Planning Application Ref: AW/43/18/OUT

Location: 261 Aldwick Road, Aldwick

Description of works: Outline application with some matters reserved for the demolition of existing dwelling and erection of two pairs of semi-detached houses and associated works

Project Title and Location		
261 Aldwick Road, Bognor Regis		
Client		
Domusea Developments Limited		
Drawing Title		
Tree Constraints Plan		
Scale	Drawn	Date
1:200@A1	LB	23.04.18
	Approved	
	JJ	
Drawing No	Revision	
LLD1425-ARB-DWG-001	00	
CAD Filename

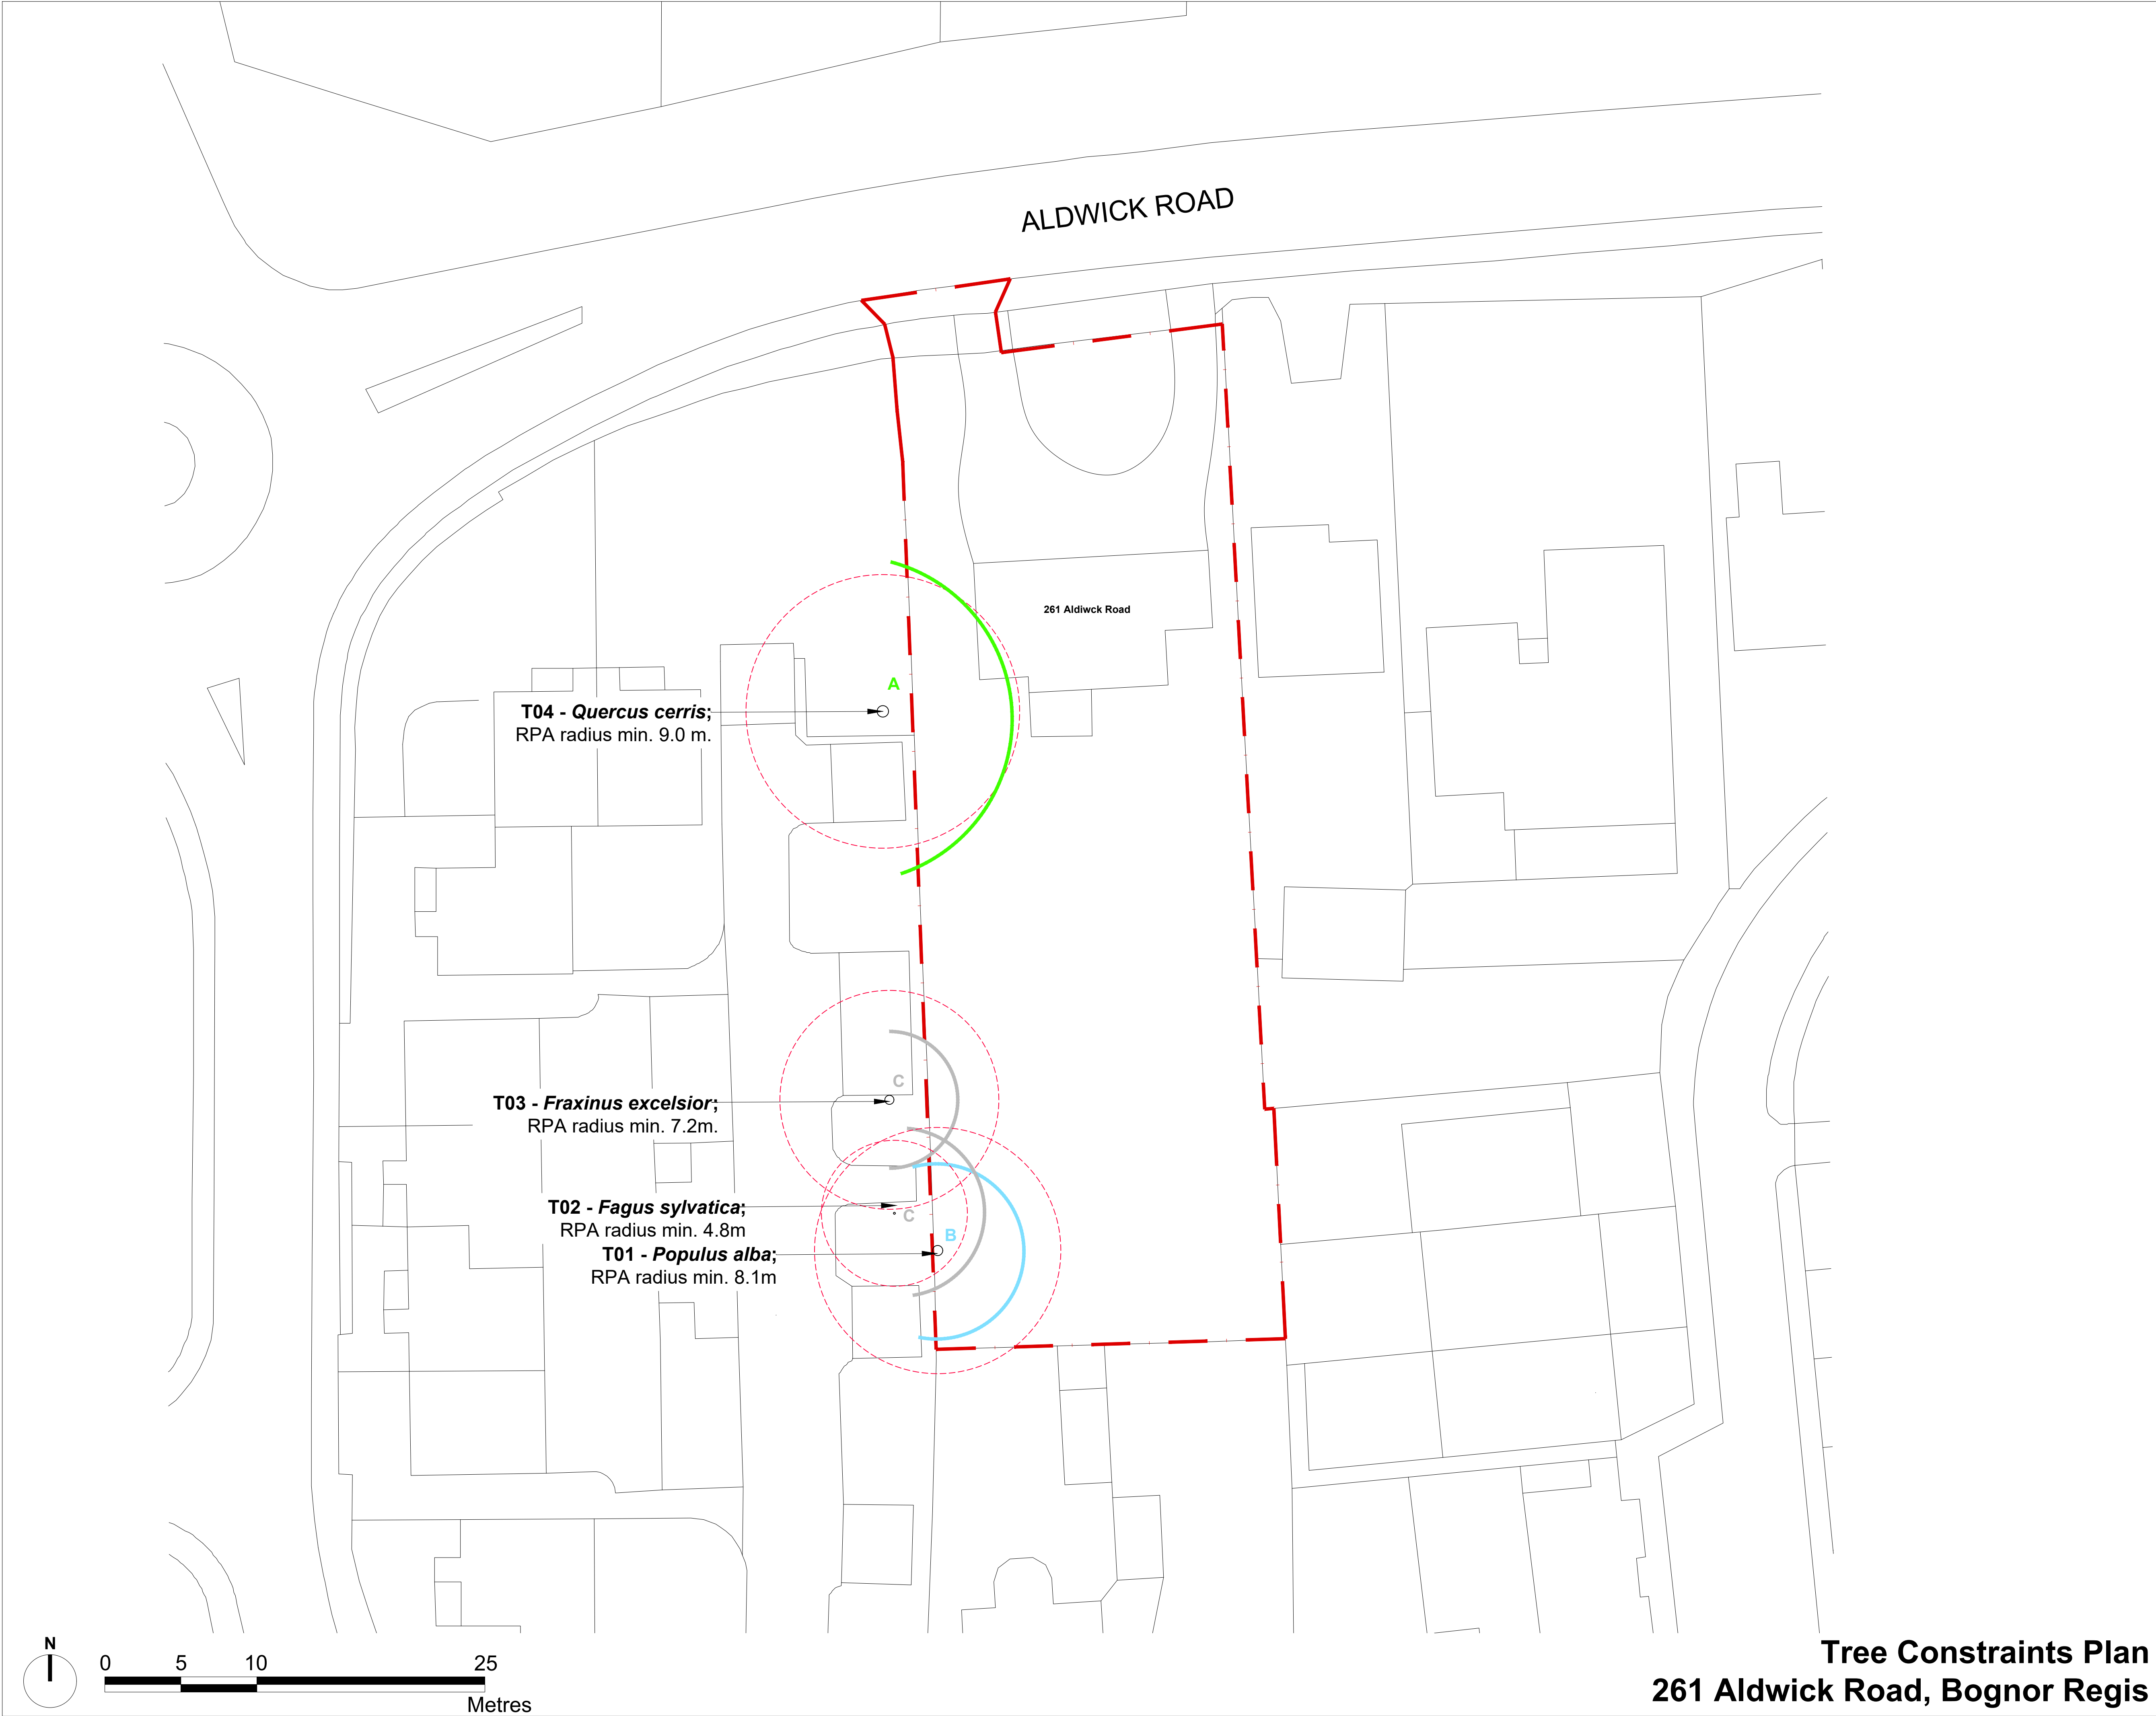
- The Tree Survey data so far as submitted accords with the requirements of BS5837:2012, although there are two notable omissions; namely two maturing sweet chestnut trees in the front garden of 259a Aldwick Road, the subject of a Tree Preservation Order (TPO/1/98/AW) and listed on the corresponding schedule as T1 and T2.

- I look forward to receiving a complete on/off site tree survey so that it fully accords with the requirements of BS5837:2012 and details mitigation measures where any RPA incursion is proposed (re: 259a Aldwick Road).
- Clarification/provision of the following items:
 - A site layout/construction plan must be provided to clearly define where delivery and storage of materials will occur and plant and compounds are to be located, throughout all phases of the development.
 - A schedule of planned visits by the site owner's appointed arboricultural consultant at all key stages of development be submitted (e.g. vegetation clearance, tree pruning, site setting-up/compound, installation of all construction exclusion zones and ground protection measures, ground clearance to facilitate/and installation of 'No-dig' cellular confinement

Project Title and Location		
261 Aldwick Road, Bognor Regis		
Client		
Domusea Developments Limited		
Drawing Title		
Tree Retention and Protection Plan		
Scale	Drawn	Date
1:200@A1	LB	23.04.18
	Approved	
	JJ	
Drawing No	Revision	
LLD-ARB-DWG-002	00	
CAD Filename

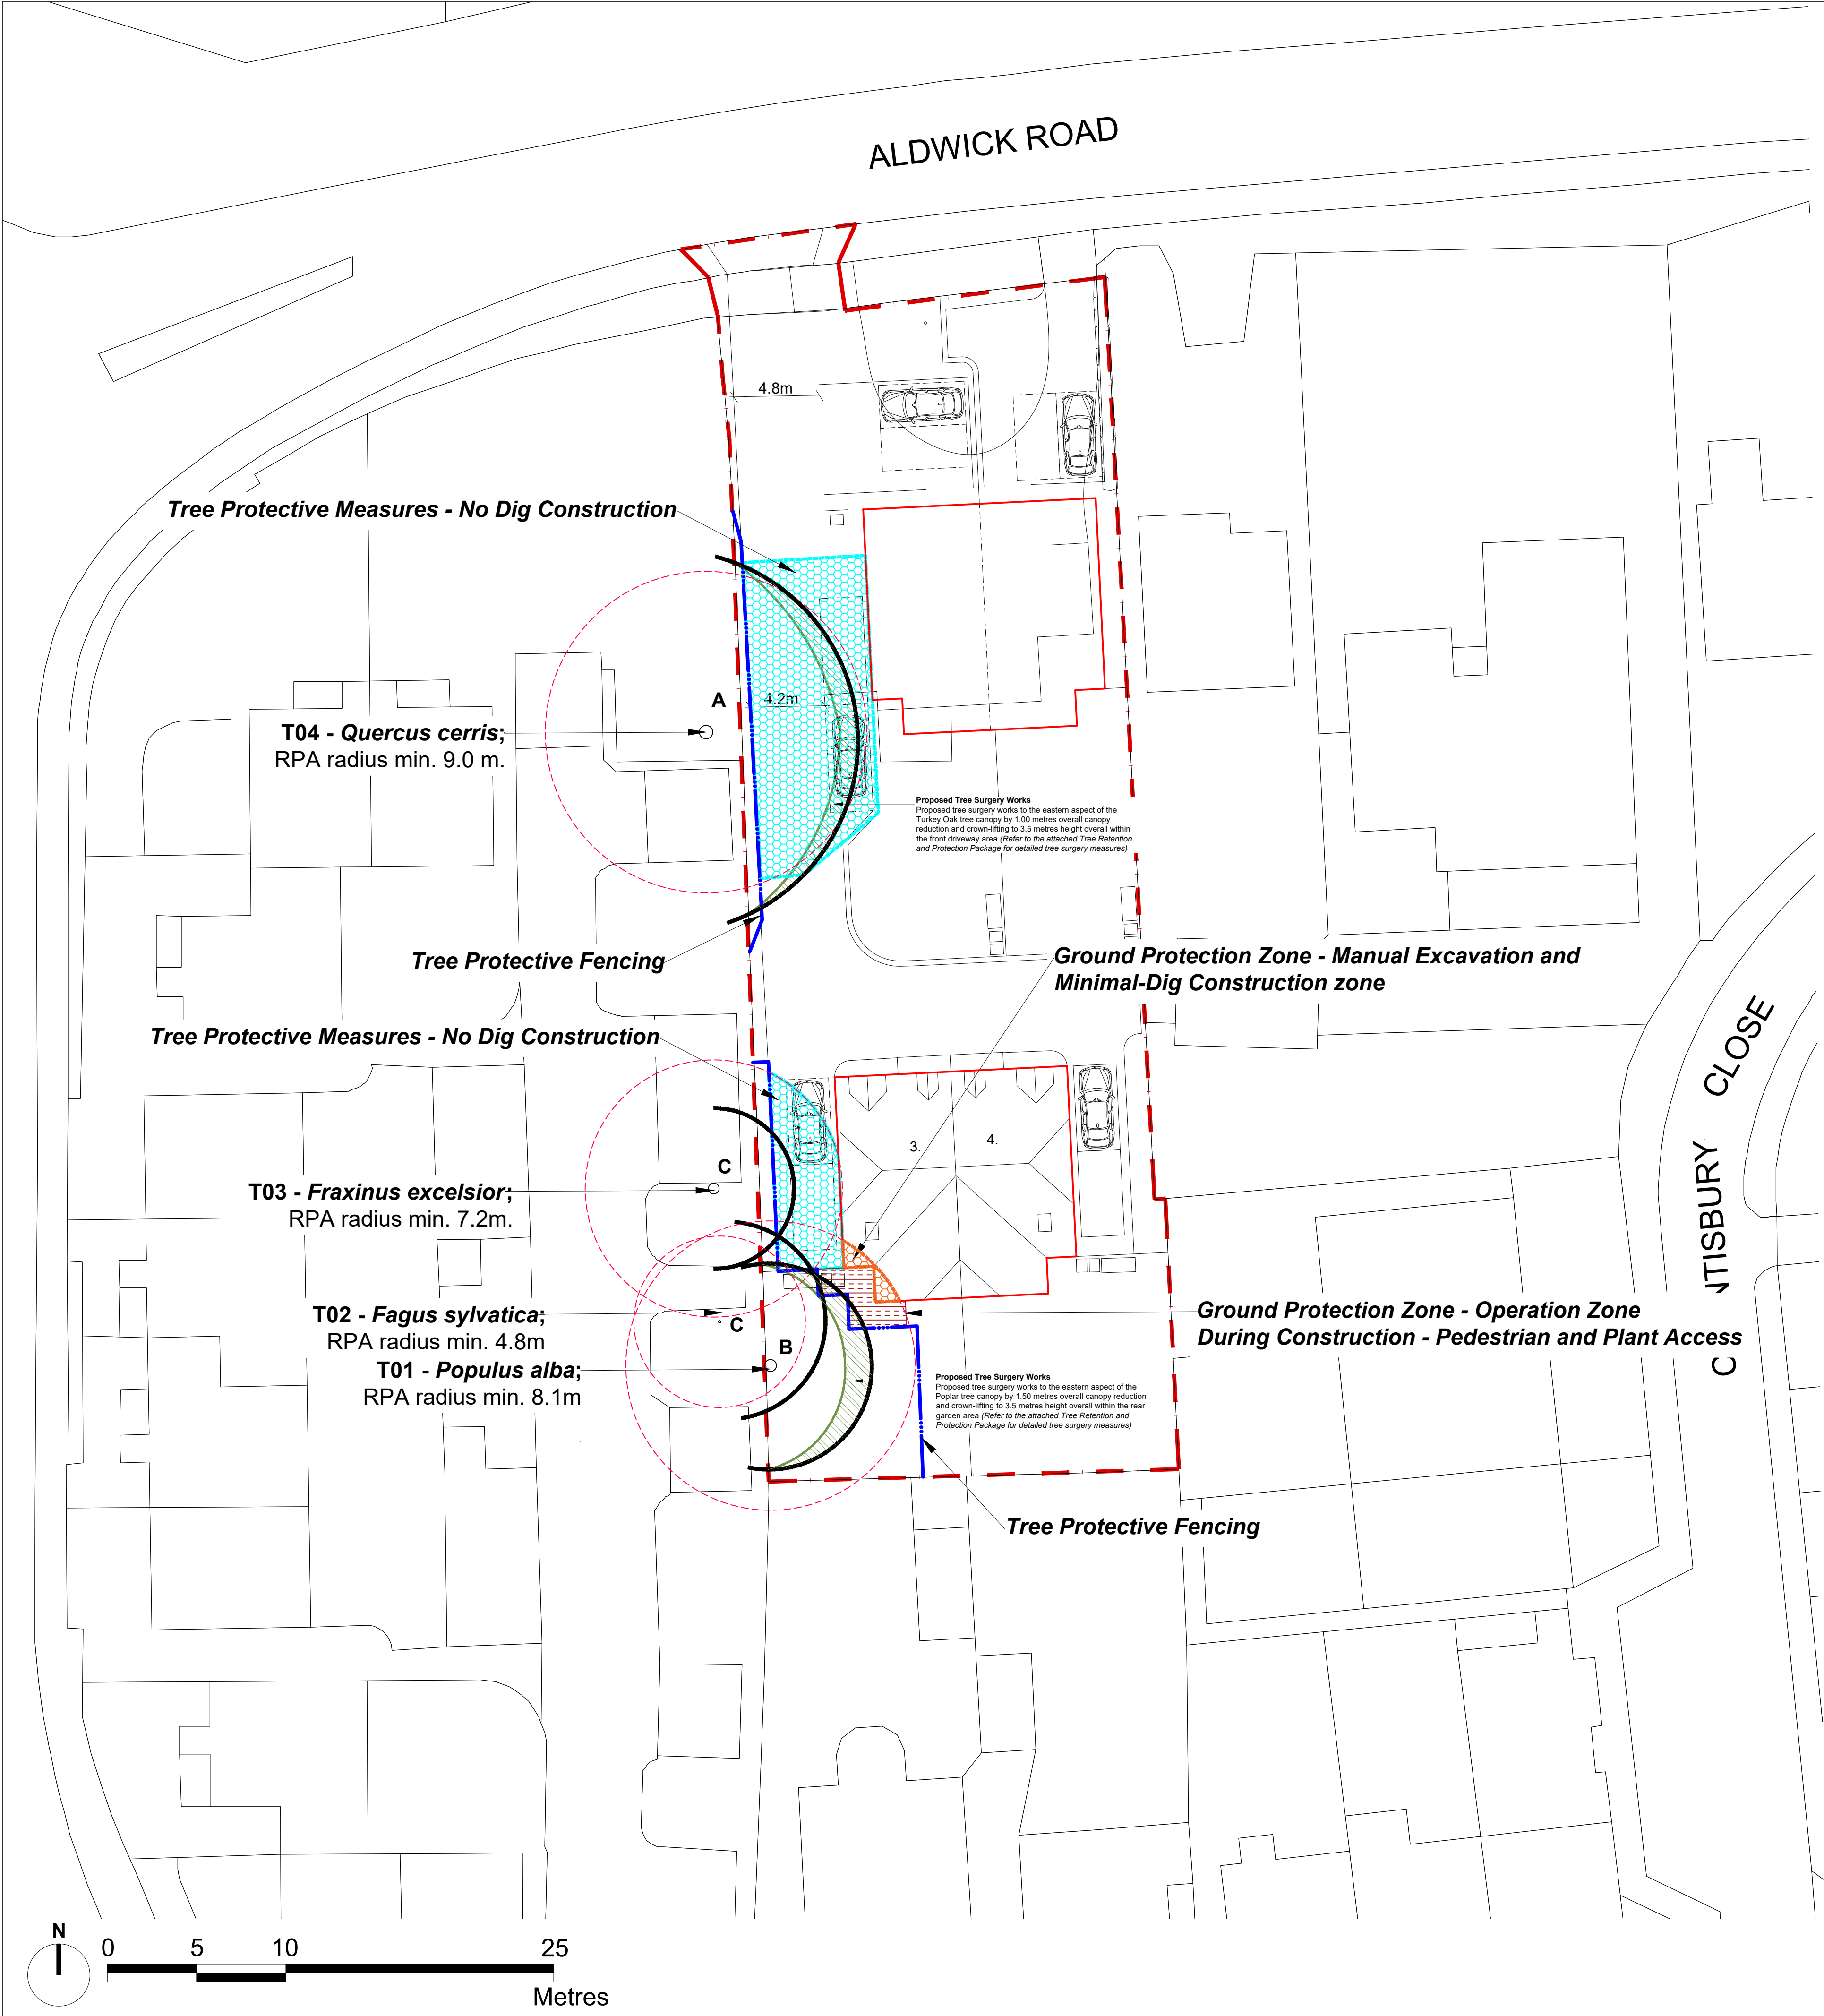
- T1 and T4 as shown on the **TPP dwg.no. LLD-ARB-DWG-002** are also the subject of an Order – TPO/AW/152/10, T-493 and TPO/AW/41/10, T-492 respectively. T4 has been incorrectly identified as a white poplar (*Populus alba*). A small matter; but for the record, it is a hybrid black poplar (*Populus x canadensis*).

- Crown reduction proposed for T04 (a fine and large example of oak) is simultaneously described as 'overall' and 'to the eastern edge of the tree canopy by 1.00 metres'. While the logical assumption is that only branches extending laterally to the east are proposed for pruning, the terminology used here leaves some room for misinterpretation and result in inappropriate work being undertaken. A reduction in top tree height usually occurs during 'overall crown reduction' – this is neither necessary or desirable and would irrevocably diminish the tree's visual amenity.

- Removal of the word 'overall' from all report/plan references to tree work specification (re: crown reduction), so as to provide absolute clarity for any tree-work contractor (arborist).
- As it stands, I must register an **OBJECTION** as there is insufficient detail/provision of information to ensure significant trees will be adequately protected during the demolition and construction phases.
